Consultation Response: Kirklees Council Conservation & Design (Biodiversity)

<i>Is this a response to an informal consultation request?</i> Yes ☐ No ☒	
Date	23/04/2018
Officer responding	Tom Stephenson
Application number	2018_90491
Purpose	Discharge of conditions
Location	120, Laund Road, Salendine Nook, Huddersfield, HD3 3TY

Figure 1. Area of retained scrub at south-east boundary of site

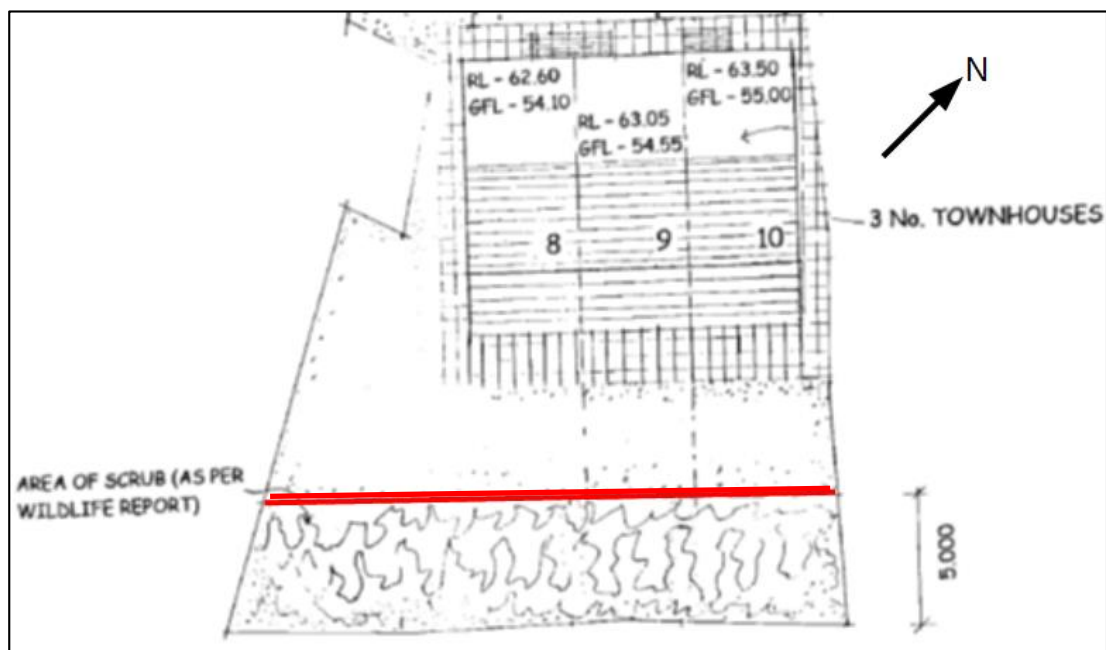
Condition 17

The submitted method statement, if implemented, is sufficient to discharge this condition.
